Recommendation Report for Planning Permission for Works or Extension to a Dwelling

REF NO: FP/261/21/HH

LOCATION: 16 Normans Drive
Felpham
PO22 8LW

PROPOSAL: Single storey side/rear extension and conversion of garage with alterations to fenestration and rendering.

Site	16 Normans Drive, Bognor Regis, West Sussex PO22 8LW	Date	10.11.2021
		Sheet	21-1867 D05 Rev 1
		Job	New Extension
		Scale	As Shown@A1
		Title	As Shown

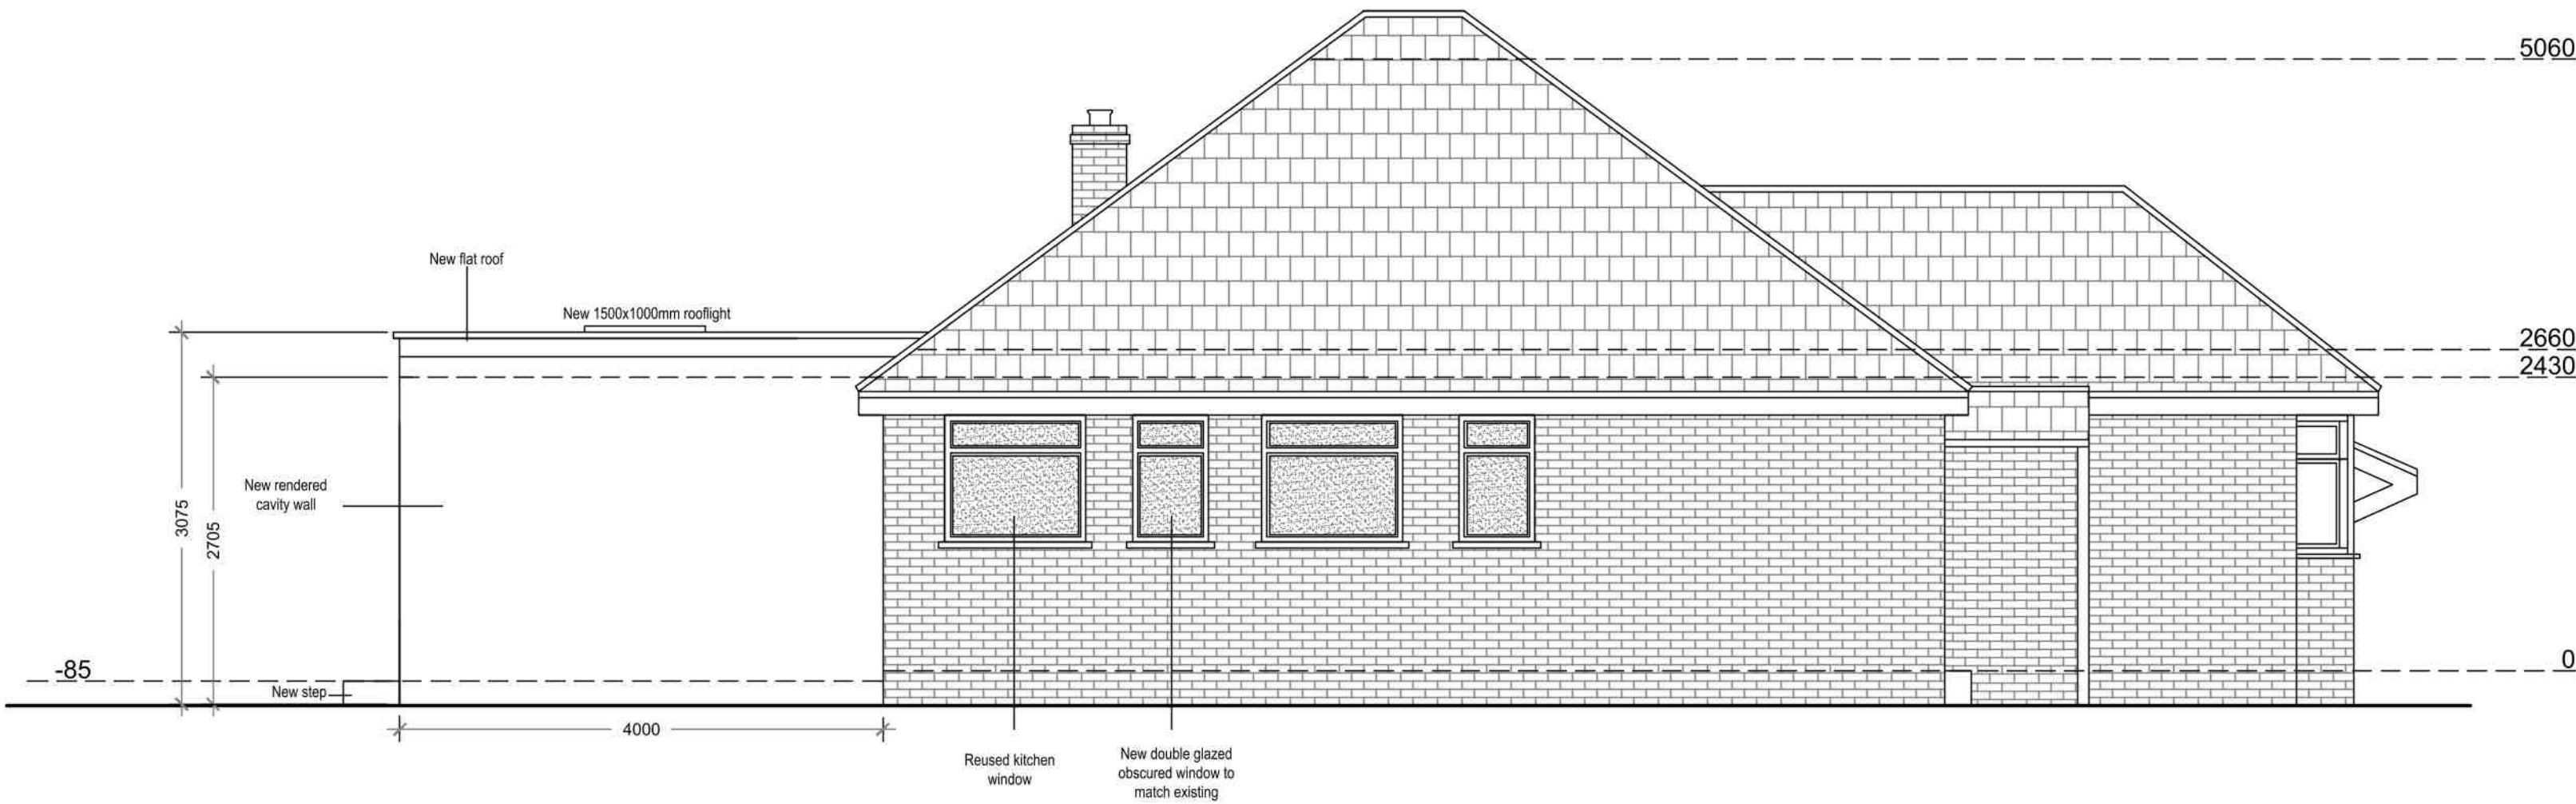
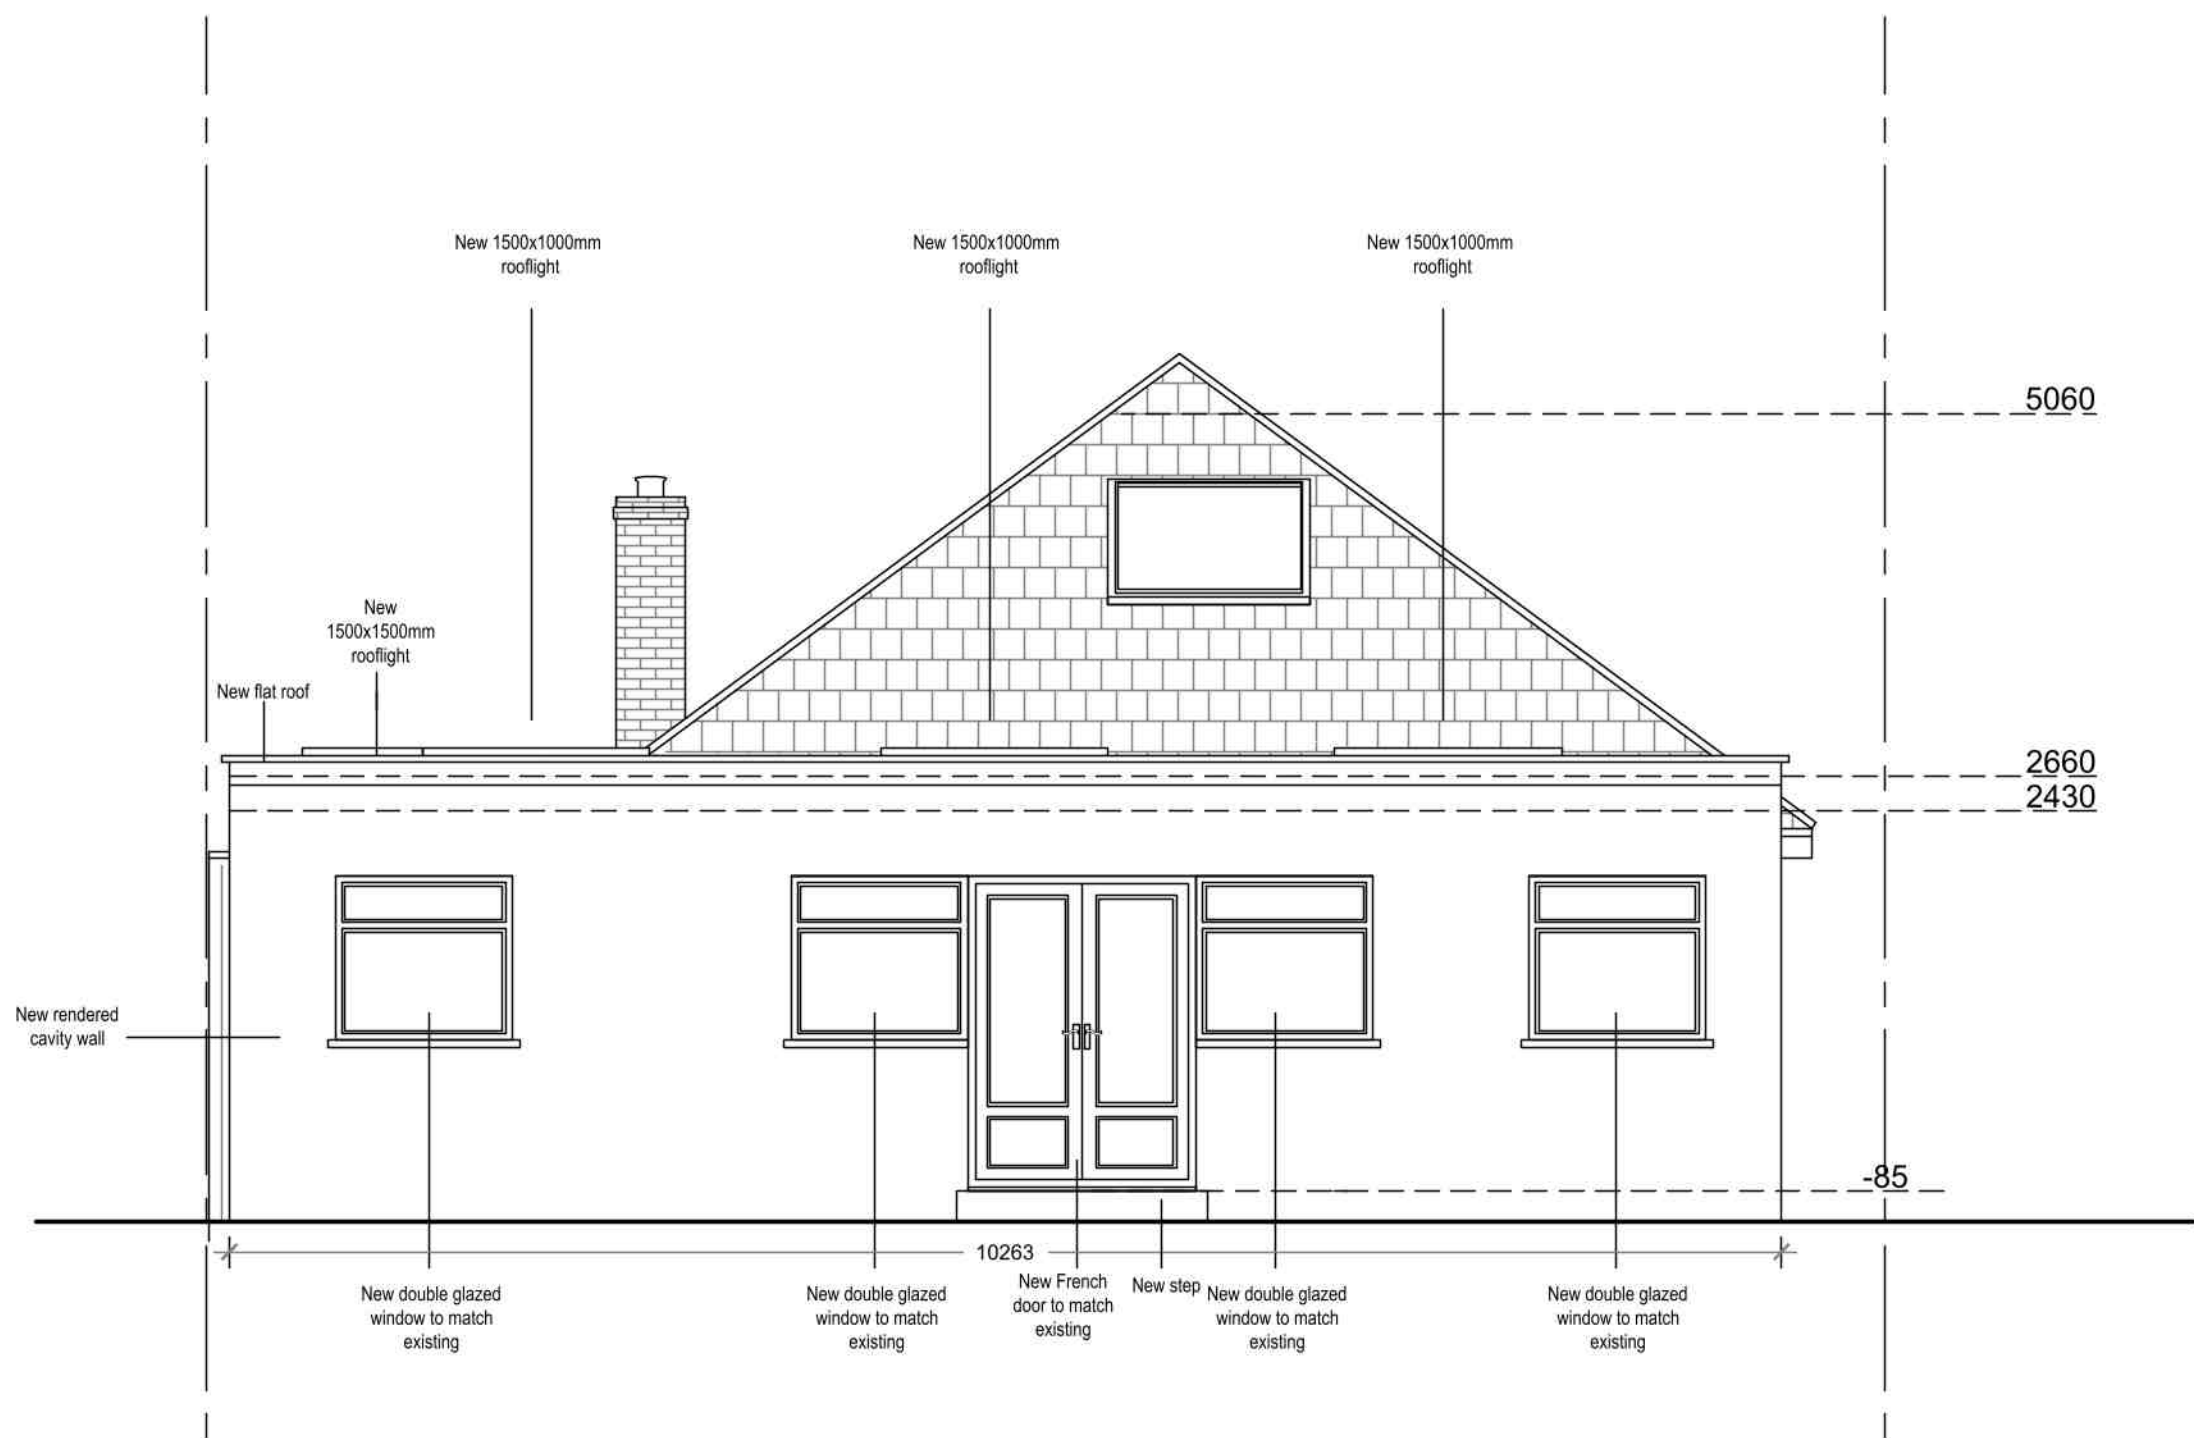
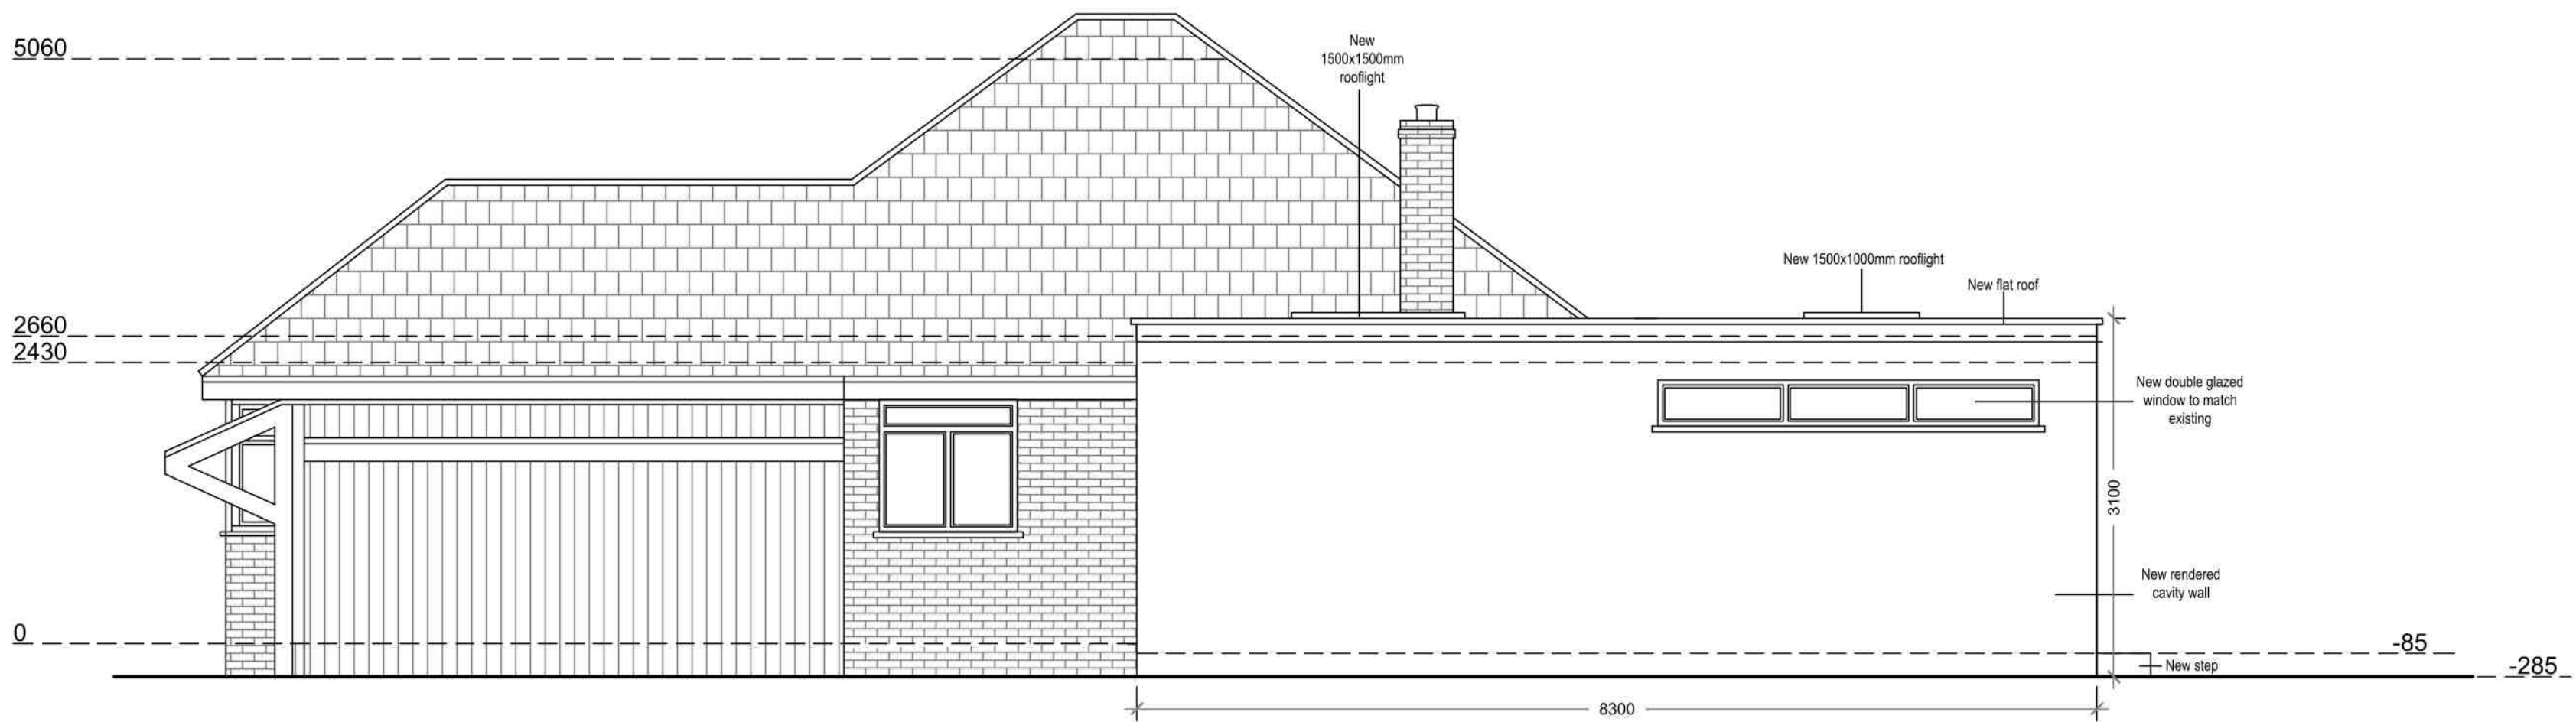
The garage conversion will be visible from the street scene as will the roof of the rear side addition as a result of its increase in height by around 0.6m. The property largely retains its existing appearance from the street scene which is in scale with the size of the host dwelling.

The side addition to the rear southern side of the dwelling will increase in height from 2.5m to 3.1m with a flat roof. This will join with the proposed rear extension. This does not result in adverse overbearing or overshadowing with the structure largely replacing existing albeit slightly increased in height.

There will be doors and windows to the rear extension overlooking the rear garden. There will also be a high level window to the side addition towards the rear of the property which due to its height above

finished floor level would not result in adverse views.
